KIRKLEES METROPOLITAN COUNCIL INVESTMENT & REGENERATION SERVICE

DELEGATED DECISION TO DETERMINE APPLICATIONS FOR CONSENT, AGREEMENT OR APPROVAL REQUIRED BY CONDITION

Reference No:	2026/44/90932/E
Site Address:	Unit 800, Bretton Park Industrial Estate, Bretton Park Way, Savile Town, Dewsbury, WF12 9BS
Description:	Discharge of details reserved by conditions 3 (CEMP), 7 CEMP (biodiversity), and 9 (EVC) on previous permission 2025/91202 for erection of three storey office extension, alteration of hard surfaced area to car park, with associated works including landscaping
Recommending Officer:	Farzana Tabasum

Officer Report

Proposed Compound Layout

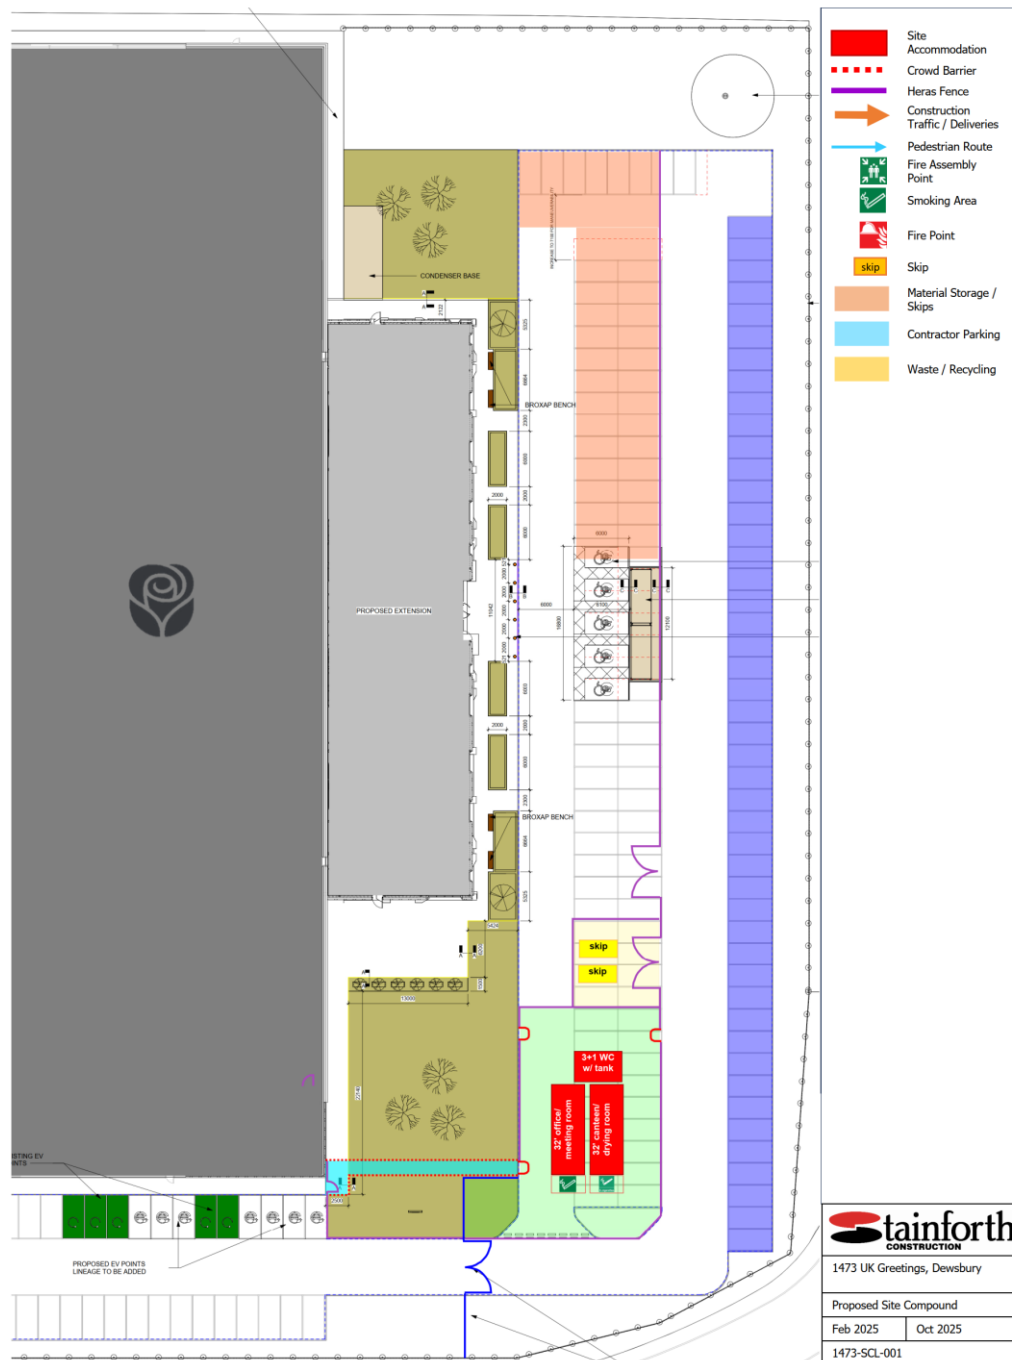
The submitted compound layout drawing (on page 8) identifies contractor parking areas within the site compound. Sufficient spaces are considered to have been demonstrated

EV CHARGING SCHEME

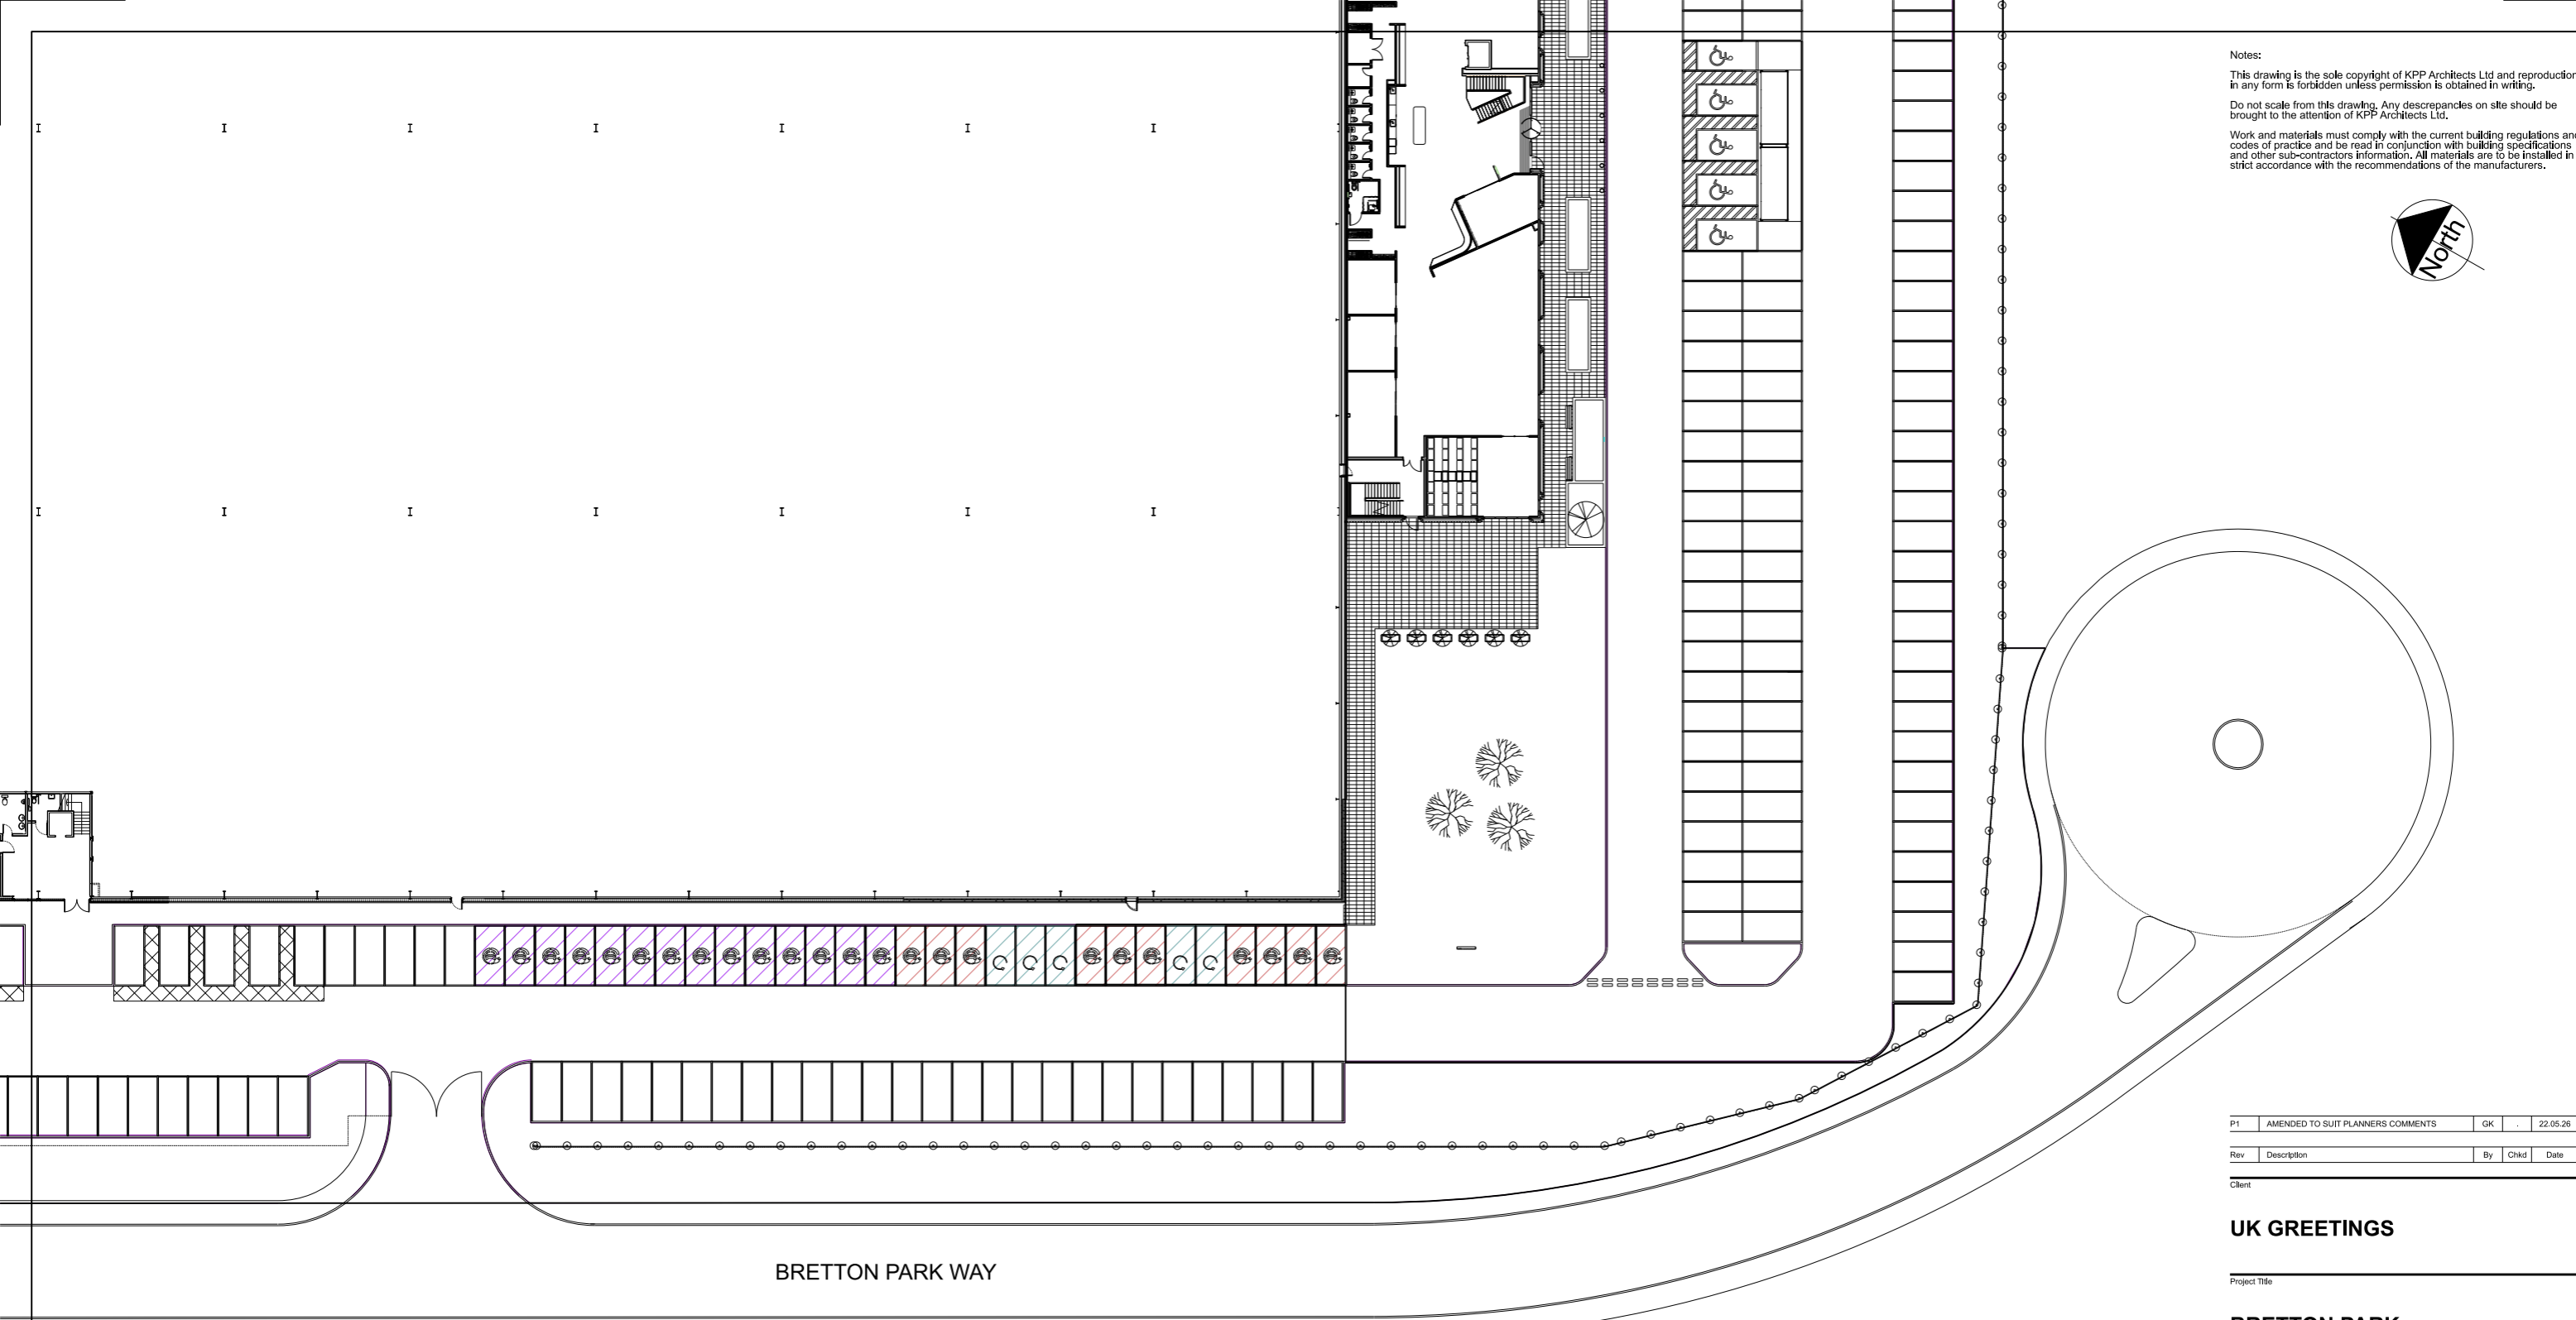
The submitted EV Charging Scheme drawing ref. 2467 P1 identifies:

- 5 existing EV charging bays;
- 10 new proposed EV charging bays; and
- 14 future proposed EV charging bays,

resulting in a total of 29 EV charging spaces.

Regarding the implementation timescales, the amended drawing identifies:

- 15 EV charging spaces available upon completion of the development comprising the 5 existing bays and 10 new proposed bays; and
- a further 14 future proposed EV charging bays.

Officers are satisfied that the submitted details therefore provide the minimum 5% initial provision required by the condition and demonstrate how the remaining provision necessary to achieve the full 10% requirement would be incorporated. Subject to the remaining 5% being incorporated within 5 years of from occupation of the extension (as confirmed via the email dated 22/05/2026) and thereafter retained for use in accordance with the approved details the requirements of condition 9 will be met.
